From: Chantelle Bashford <Chantelle.Bashford@arun.gov.uk>
Sent: 12 February 2021 12:01
To: Planning.Responses <Planning.Responses@arun.gov.uk>
Subject: RE: Planning Consultation on: BR/298/20/PL

Please see Private Sector Housing comments, below. These comments are in relation to general housing conditions and have regard to the Housing Act 2004, Housing Health and Safety Rating System (England) Regulations 2005 and LACoRS national fire safety guidance.

Application No: BR/298/20/PL
Registered: 4th January 2021
Site Address: 25 Sudley Road Bognor Regis PO21 1EW
Grid Reference: 493526 99326
Description of Works: New 2 storey extension on first floor with loft floor including 8 (4 front & 4 rear) dormer windows, first floor rear extension (mansard floor) with 8 No roof windows, alterations to ground floor shopfront and new access to upper floor into use for 10 residential units (5 No 1-bed & 5 No 2-bed) (resubmission following BR/196/20/PL). This application may affect the setting of a listed building & the site is in CIL Zone 4 (Zero Rated) as flats.

PROPOSED
- GROUND FLOOR PLAN

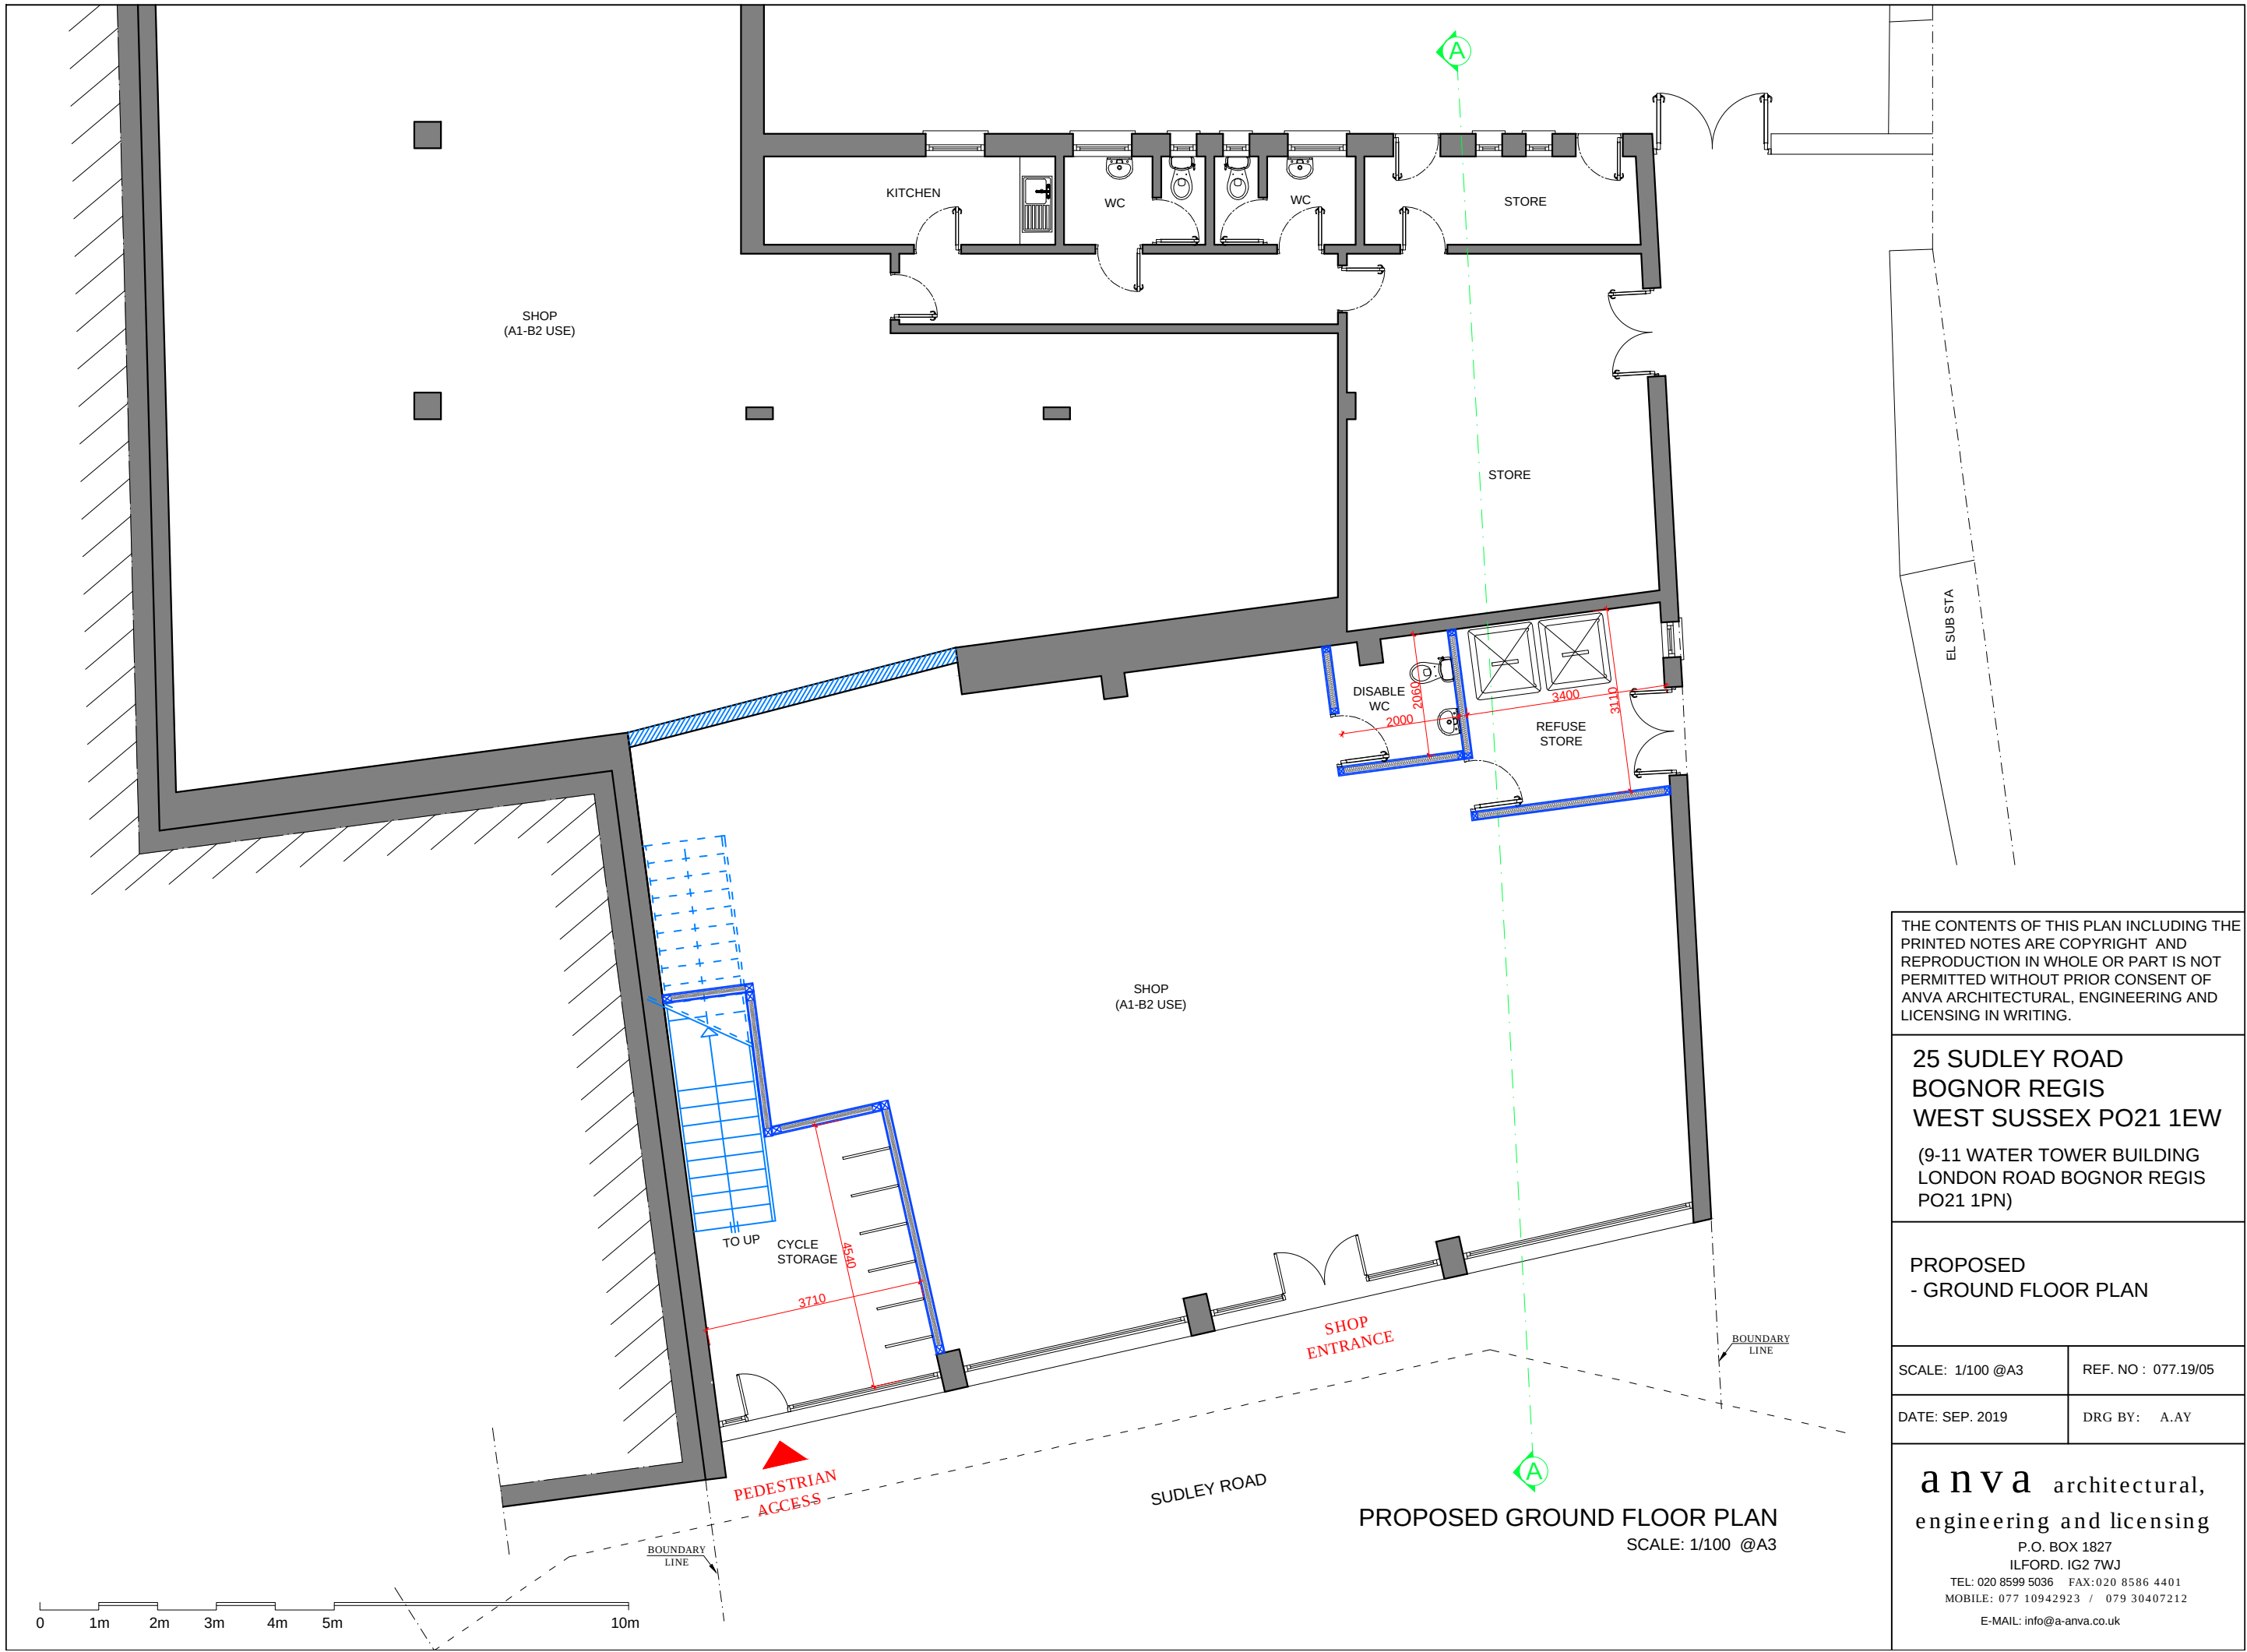
- Appropriate fire precaution facilities and equipment must be provided of such type, number and location as are considered necessary. Guidance on fire safety is contained in the LACORS guidance document – “Housing – Fire Safety, Guidance on fire safety precautions for certain types of existing housing”
- The external fire escape serving the first and the second floor should be protected from the effects of fire along its length. The sensitive area is 1.8m horizontally, therefore any windows in this region should be of fire resisting construction and any doors should be fire resisting and self-closing
- There should be adequate fire separation (usually 60 minutes) between the commercial units on the ground floor and the residential flats above

- The internal escape route should provide 30 minutes fire resistance, including the provision of 30 minute fire resisting and self-closing fire doors (FD30S) to each flat entrance
N.B. The location of the electrics does not appear to be included within the plans. If they are located within the 'CLE STAFF' cupboard on the first floor landing then a FD30S door will be required to this cupboard. If they are located along the escape route, a 30 minute fire resisting enclosure must be provided

PROPOSED
-SECTION A-A

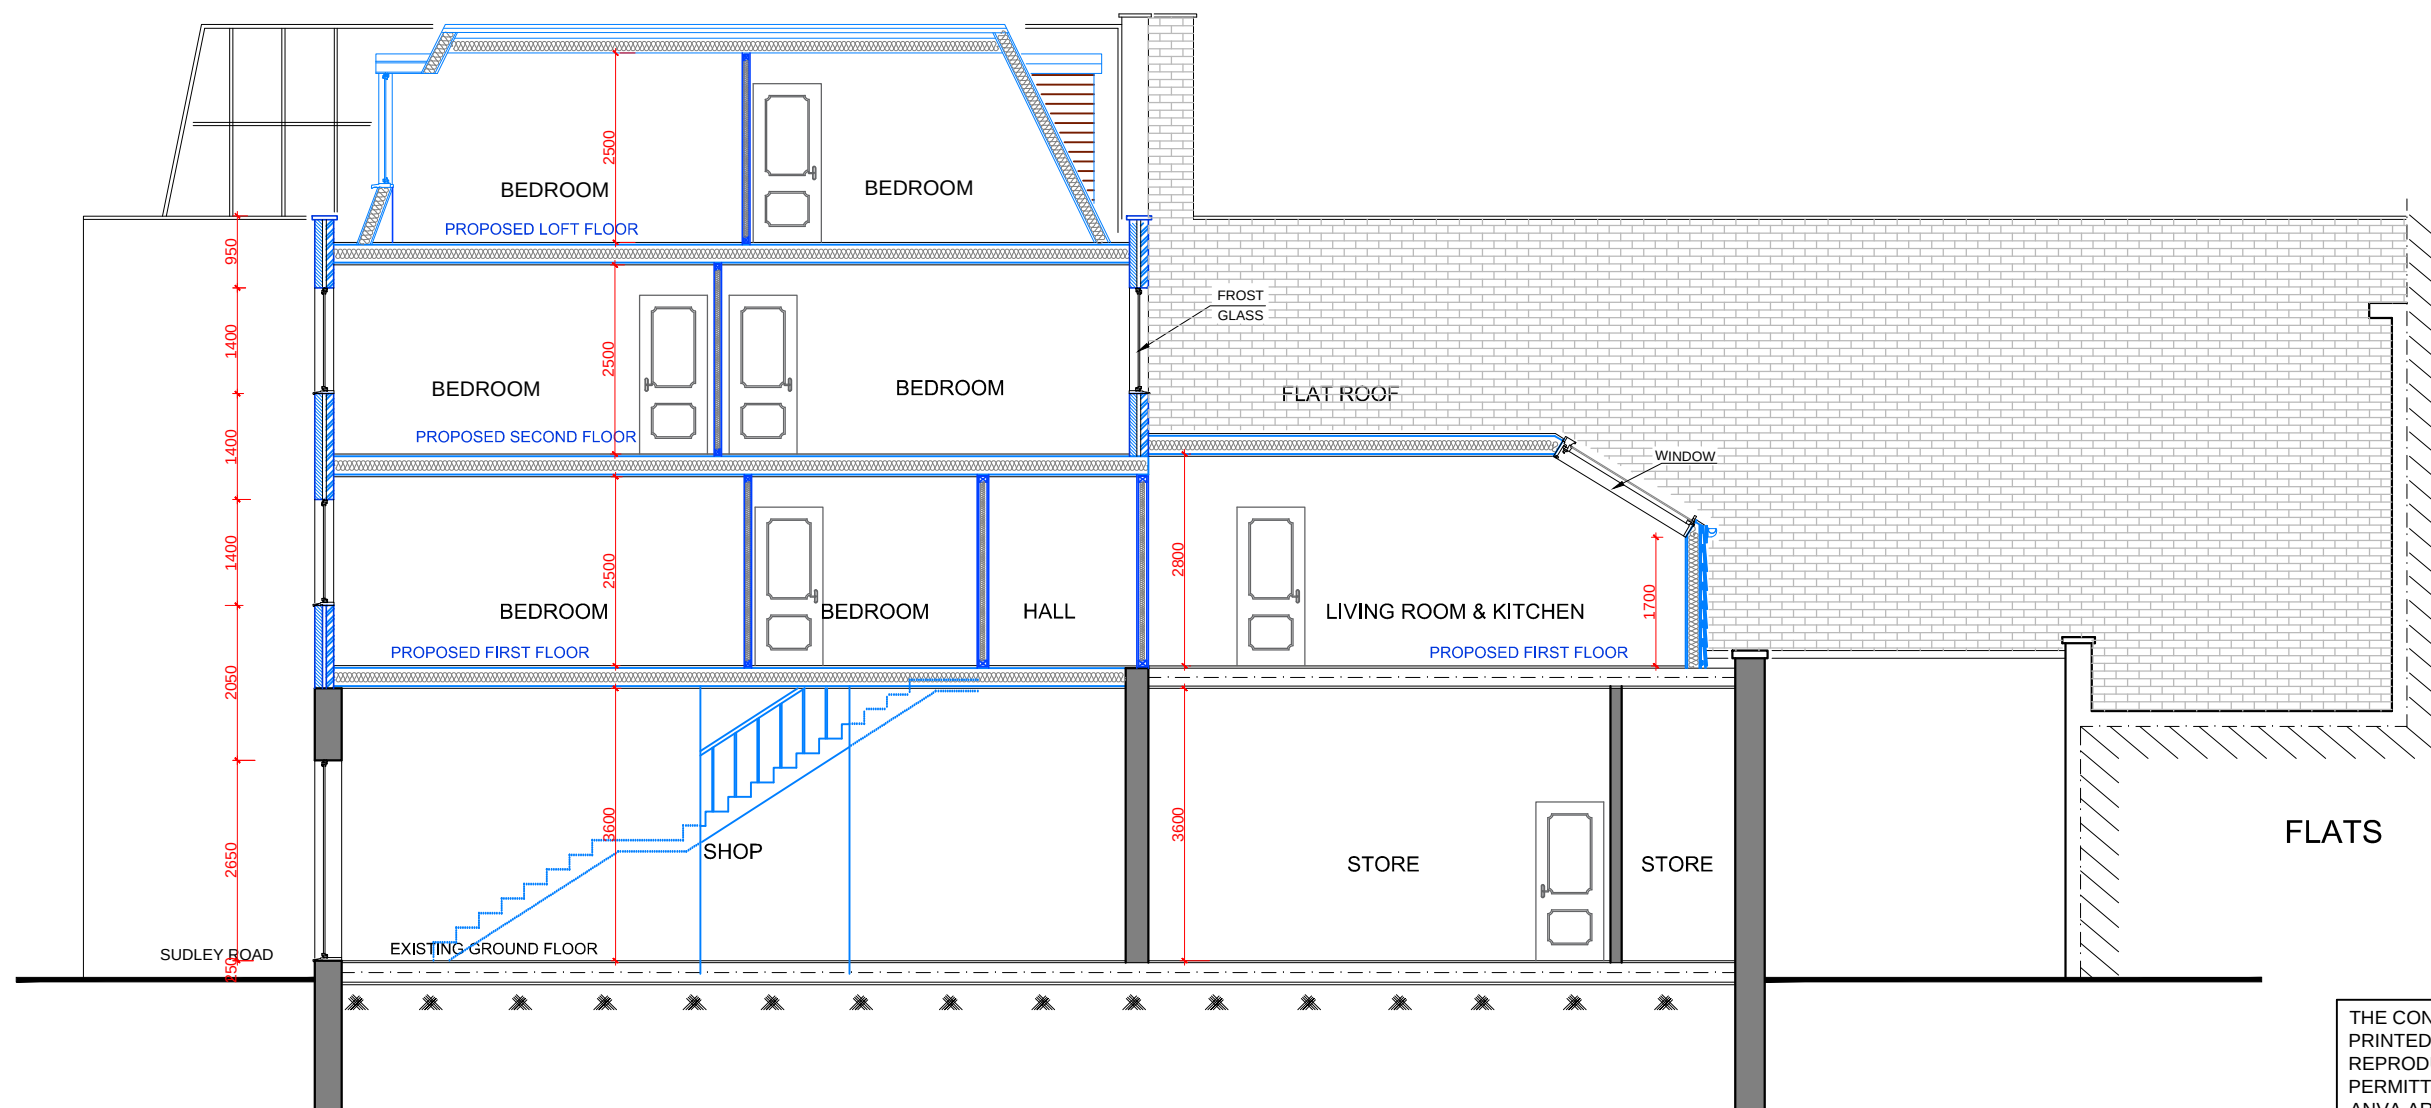
- Opening limiters should be installed to all windows above the ground floor to prevent windows being opened more than 100mm. Opening limiters should not be key operated
- The roof windows serving flats 1, 2, 3 & 4 should be of an appropriate height and angle to provide a reasonable view outside of the immediate surroundings
